**WELWYN HATFIELD BOROUGH COUNCIL – DEVELOPMENT MANAGEMENT  
DELEGATED REPORT**

<b>APPLICATION No:</b>	<b>N6/2013/1732/FP</b>
<b>APPLICATION Site:</b>	<b>2 Hornbeam Lane, Essendon</b>

This application seeks planning permission for the erection of a single storey rear extension following demolition of the existing conservatory and store room.

Dwg. No  
BC303-2

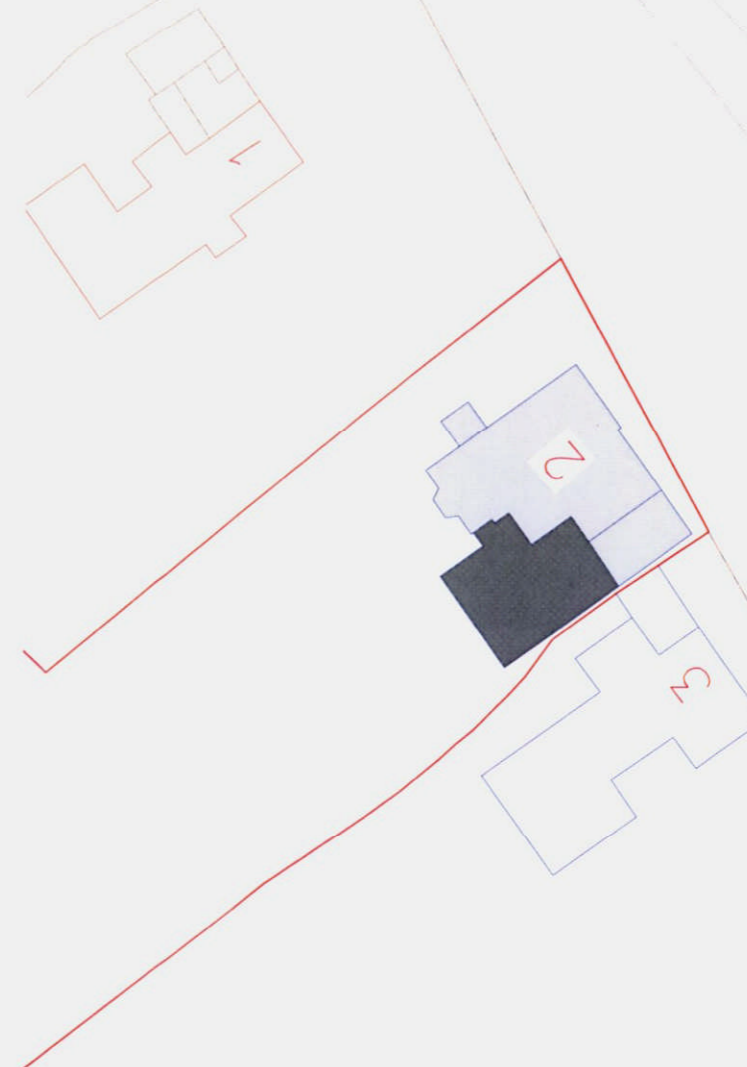
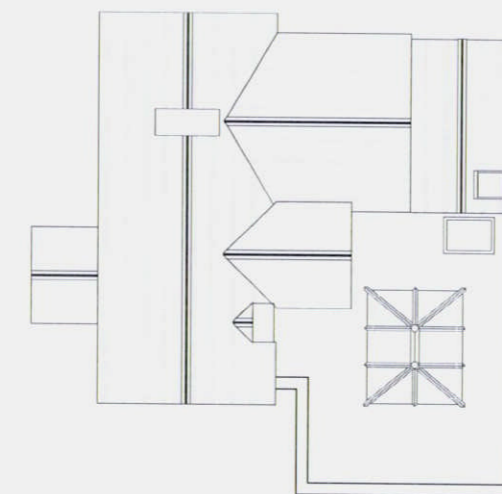
The existing dwelling is approximately 58% larger than its original size and the proposal would result in a dwelling that is 68% larger than the original size. An increase in size beyond that of the original dwelling of 68% is considered to be disproportionate. However, on the basis that the proposal involves the replacement of part of previous extensions to the dwellinghouse, the impact of the increase in size must be further considered.

considered that the proposed extension would appear as a dominant addition to the original dwellinghouse that would fail to respect and relate well to the host dwelling and its surroundings.

The openness of the Green Belt is considered to be one of its most important attributes and it needs to be safeguarded. As noted above, the proposed extension would be located to the rear of the host dwelling where it would not be publically visible. However it would extend beyond the original rear building line by approximately 3 metres, with a width of approximately 6 metres. This would make the overall building significantly bulkier at ground floor level.

There is already a conservatory that extends beyond the original building line at the host dwelling but it is more modest in size and appearance than the proposed extension. On this basis, there would be increased impact on the openness of the Green Belt as a result of the proposal.

The host dwelling has an attractive appearance. Although it has been extended in the past the overall building is made up of smaller elements that work well together to create a building that appears well proportioned, carefully designed and sensitively extended. Although only single storey in height, the scale of the proposed extension is not considered to be appropriate to the host dwelling. The roof height of the extension would be above the level of the tile hanging detail on the main dwellinghouse meaning the extension would appear out of scale with the host dwelling and it would not appear subservient to the host dwelling. The lantern feature on the flat roof is considered to be overly large in size and the expanse of glazing on the rear elevation would be at odds with the more delicate fenestration on the rest of the host dwelling. It is recognised that when extending a historic building it is sometimes appropriate to use a contrasting design, however in this case, the proposed extension is considered to be too large in scale and too boxy in design in relation to the host dwelling. On this basis, it is not considered that the proposal complies with the guidance set out in the NPPF or Policies D1 and D2 of the Welwyn Hatfield District Plan.

1. The site lies within the Metropolitan Green Belt where there is a presumption against inappropriate development. The proposed extensions would result in a disproportionate increase in the size of the original dwelling and would have an adverse visual impact on the openness of the Green Belt and also the character, appearance and pattern of development in the surrounding area. Furthermore, the proposed extension would represent a bulky addition to the host dwelling that does not respect and relate well to the host dwelling. As such, the proposals represent inappropriate development and as no very special circumstances have been advanced of sufficient weight to set aside Green Belt policies of restraint, the proposals are contrary to the advice contained in the National Planning Policy Framework and would conflict with Policy RA3 of the Welwyn Hatfield District Plan 2005.

in size and revisions to the detailed design and height of the proposed rear extension.
